DECISION DELEGATED TO HEAD OF PLANNING

Application No: H16-1057-24 **Applicant:** Mr D Needham
Proposal: Erection of 1 Bed 1.5 storey dwelling
Location: Rear Of 8 Sandringham Walk Spalding Lincolnshire
Terminal Date: 11th February 2025

Drawing Name
Proposed First Floor Plan

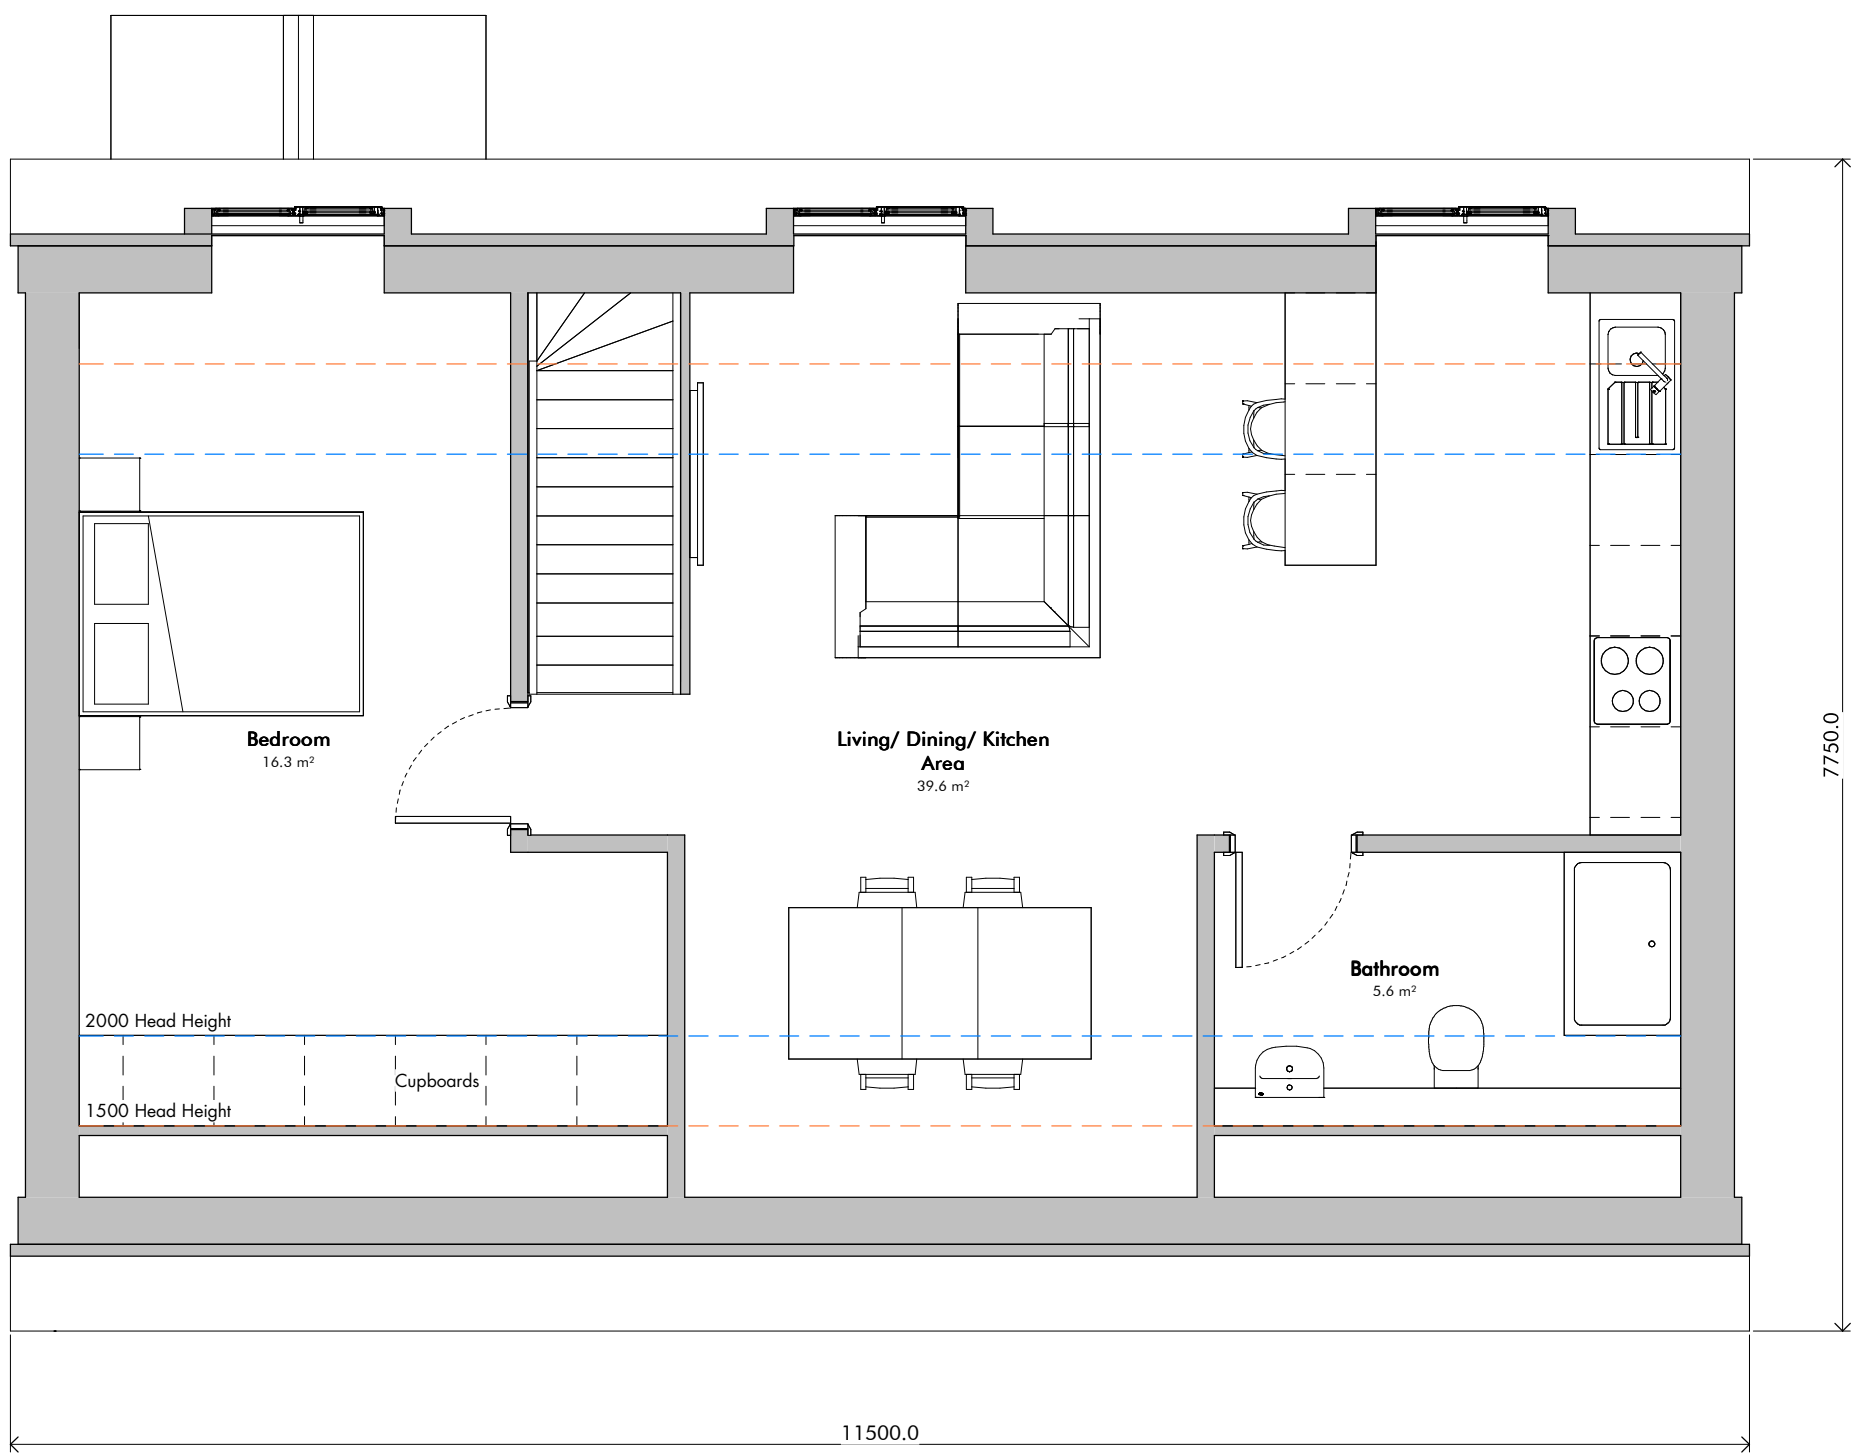
All living accommodation would be located on the first floor. Due to the reduced height of the chalet bungalow, significant portions of the dwelling would suffer from a reduced floor to ceiling height. That being said, approximately 40sqm of the floor would have a clearance of over 2 metres, and approximately 33sqm of this would have a clearance of 2.3 metres. This results in slightly over 75% of the living accommodation having a floor to ceiling height of greater than 2.3 metres, therefore

Therefore, while the sloping roof, coupled with the relatively low ceiling height may result in more claustrophobic conditions, the actual level of space provided is suitable and in accordance with the relevant guidance documents.

Elevation 1

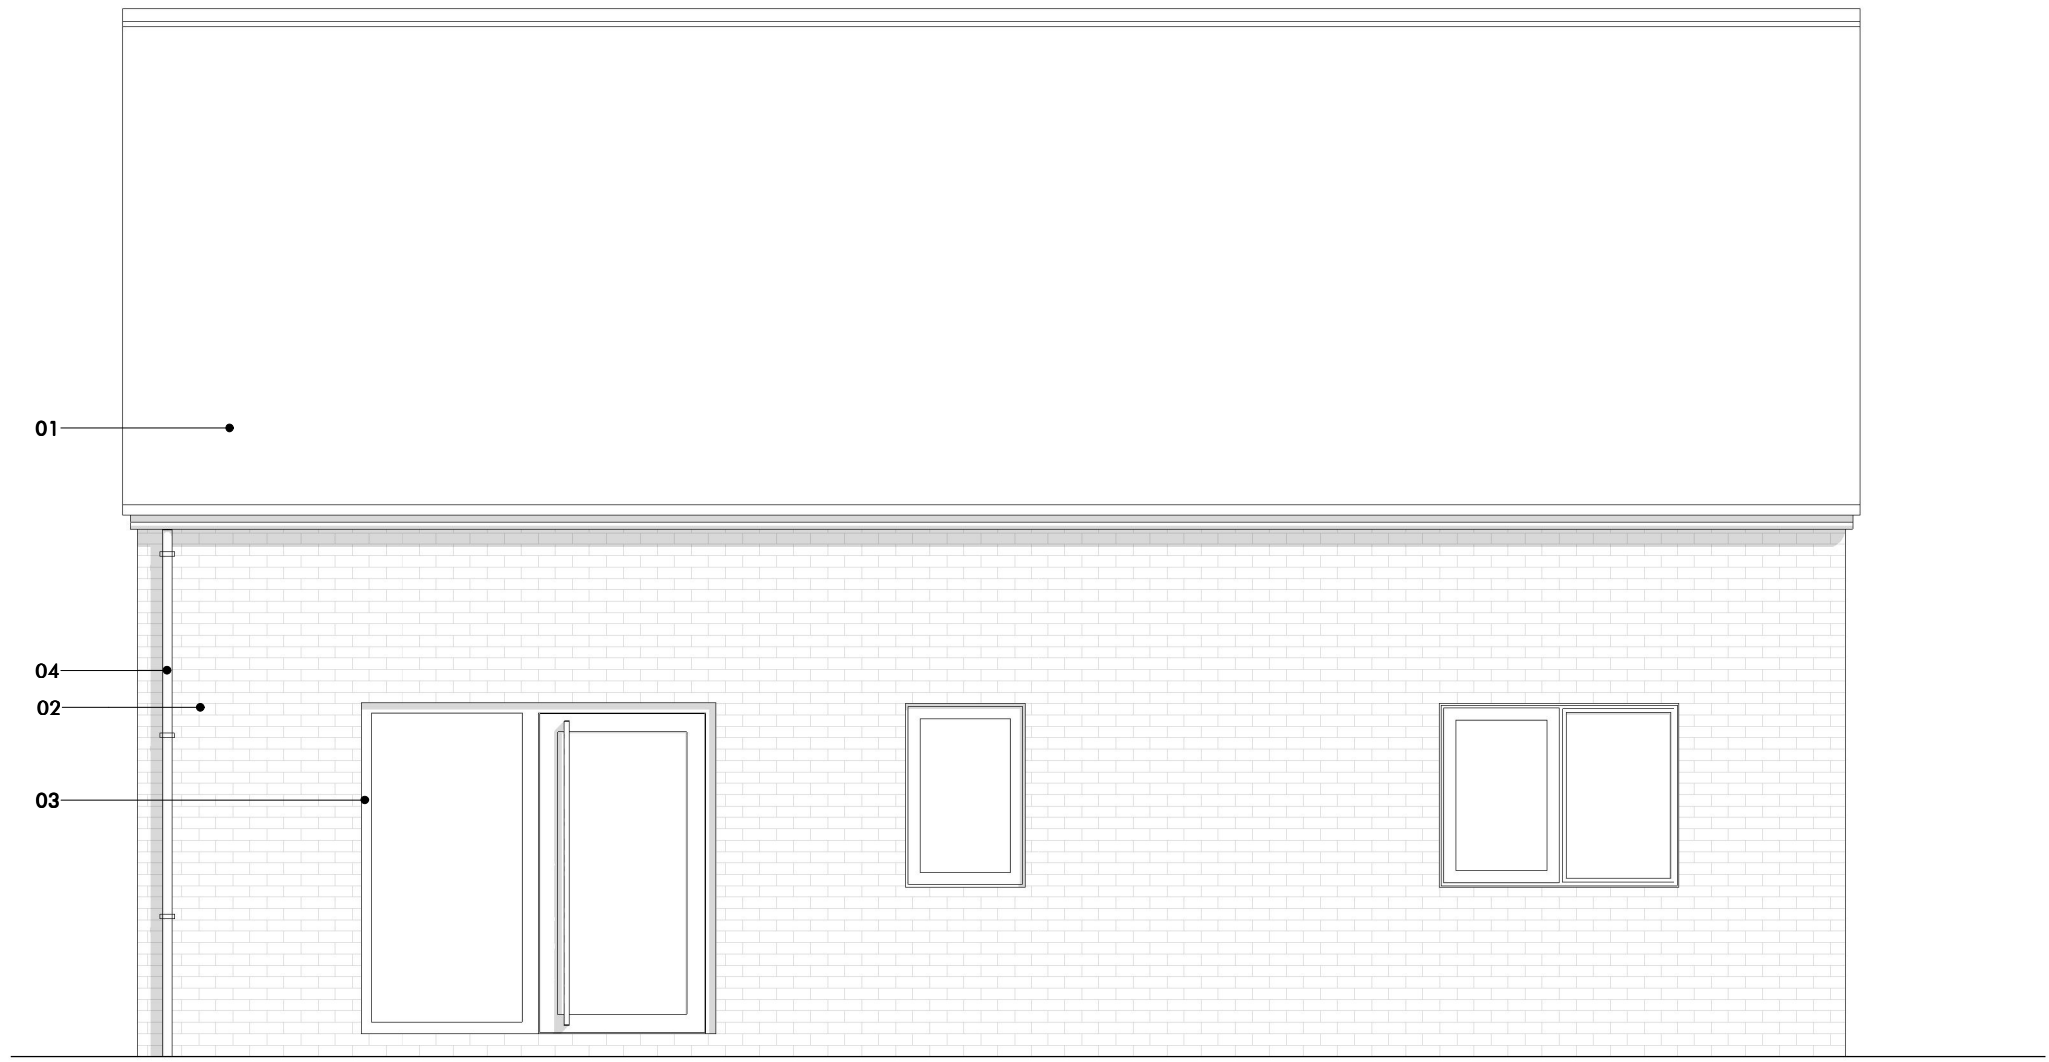
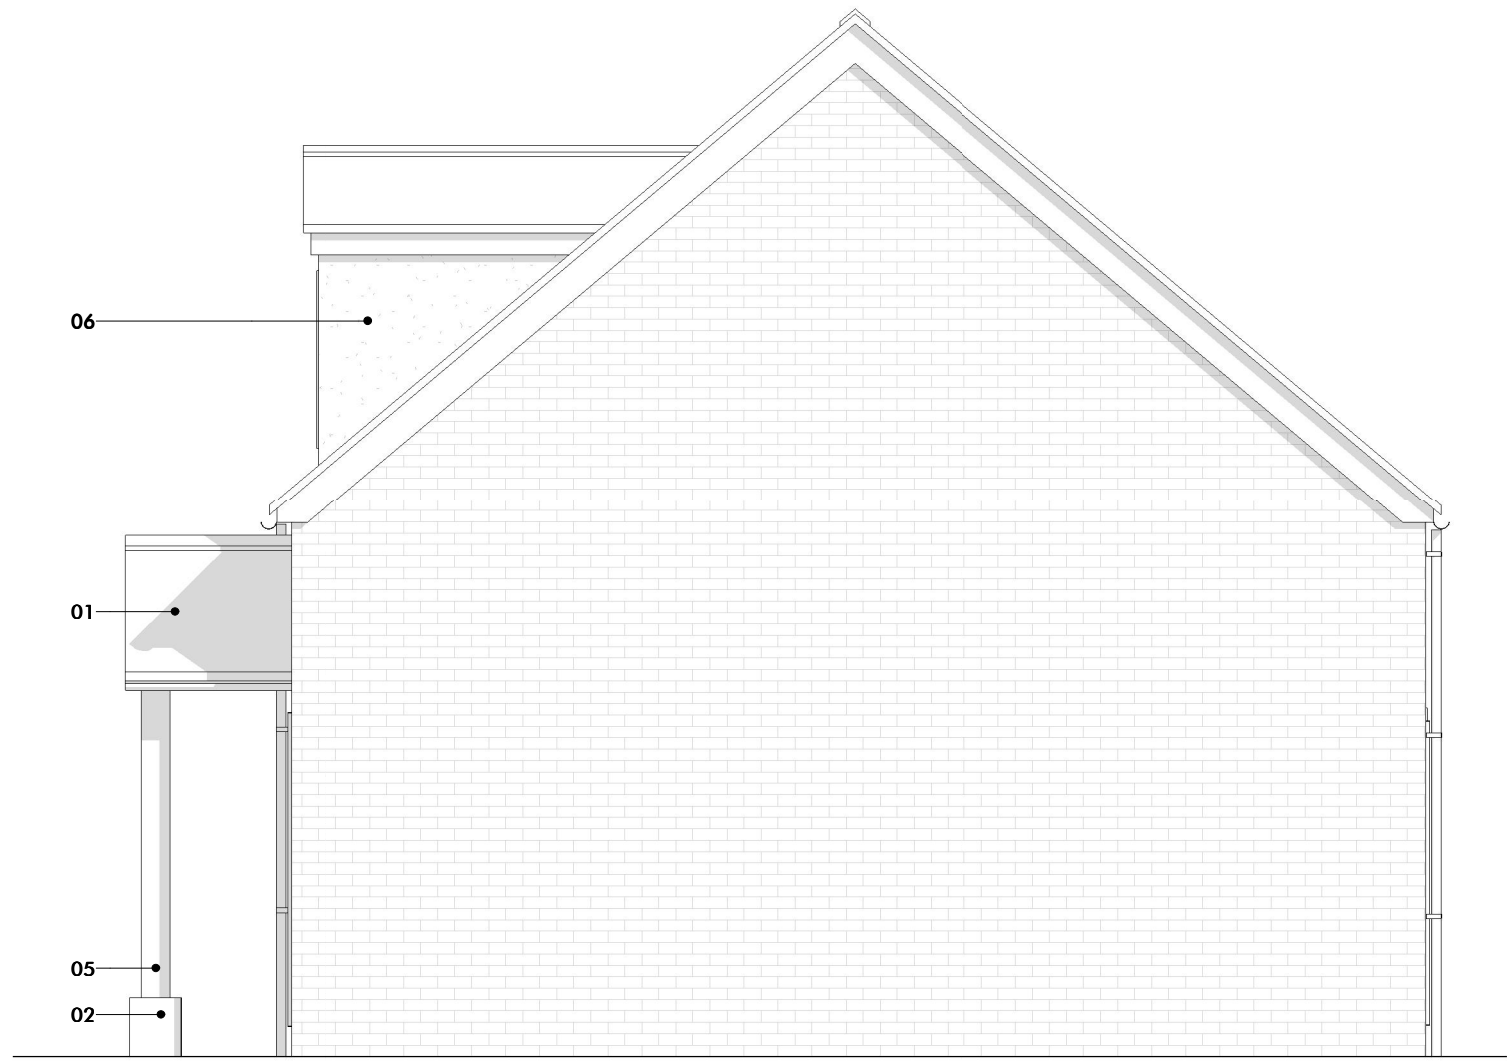
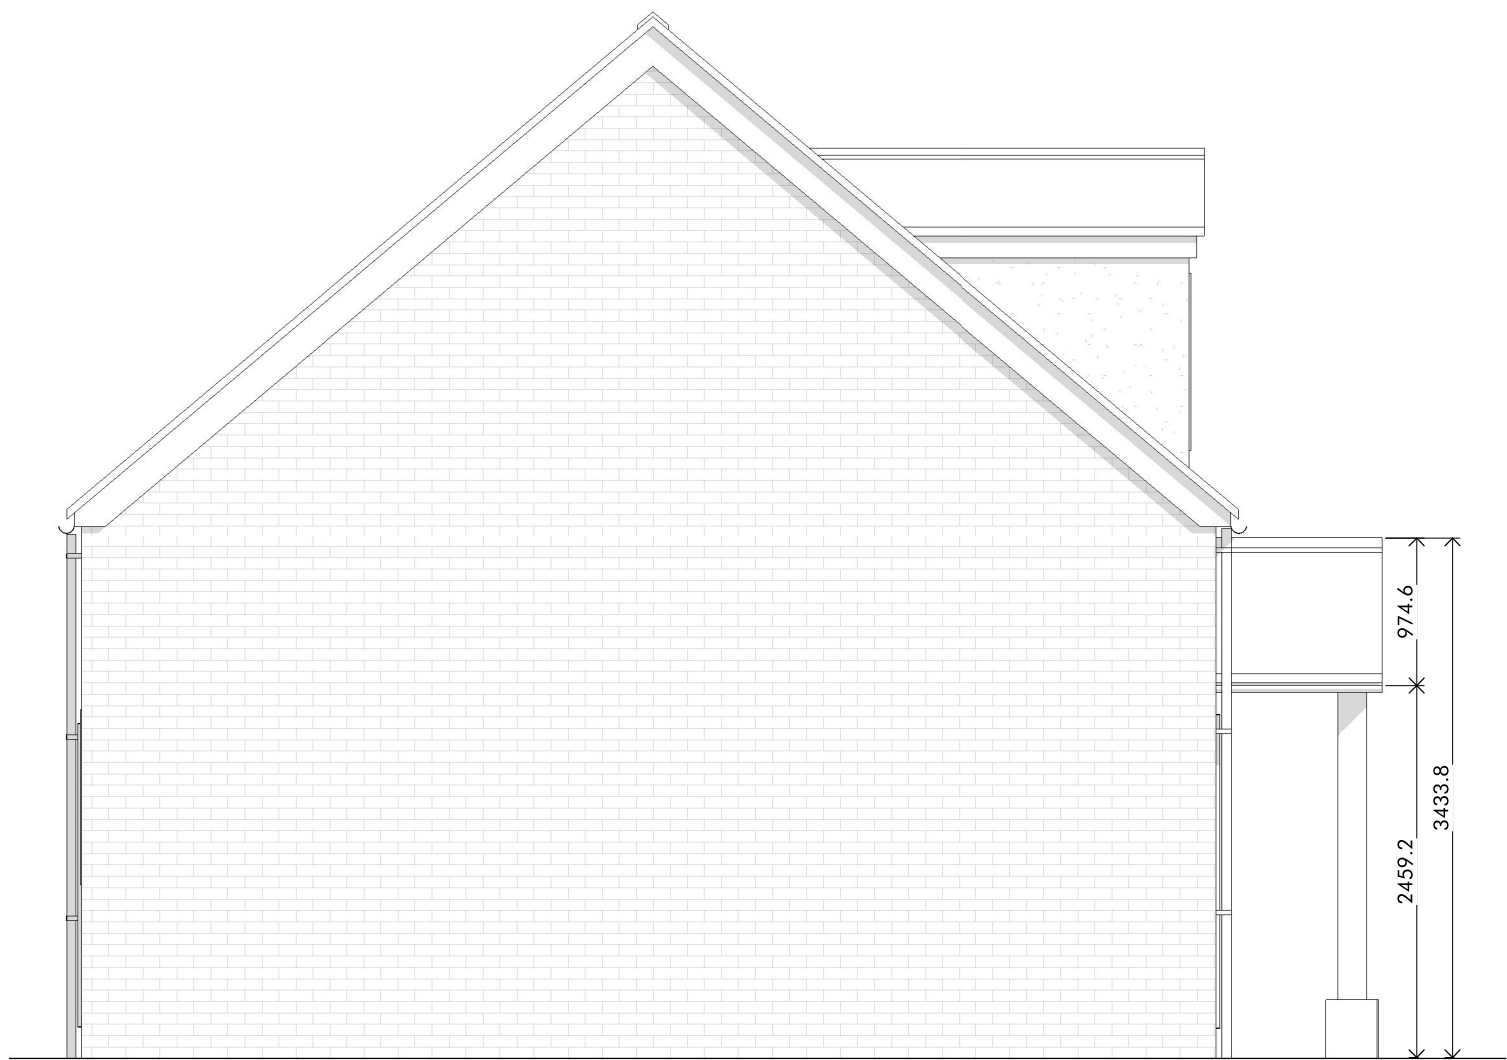
The dwelling would measure 7.5 metres (depth) by 11.3 metres (width). The dwelling's height to the eaves would measure 3.52 metres, rising to 6.919 metres at the apex of its dual pitch roof. Three dormer windows are proposed, facing southwards to Churchill Drive.

It is proposed that the dwelling would be constructed of buff brickwork, with white render to the dormers. Dark grey/ black concrete roof tiles are proposed. UPVC doors and windows are proposed. No specific details of any of these materials have been proposed.
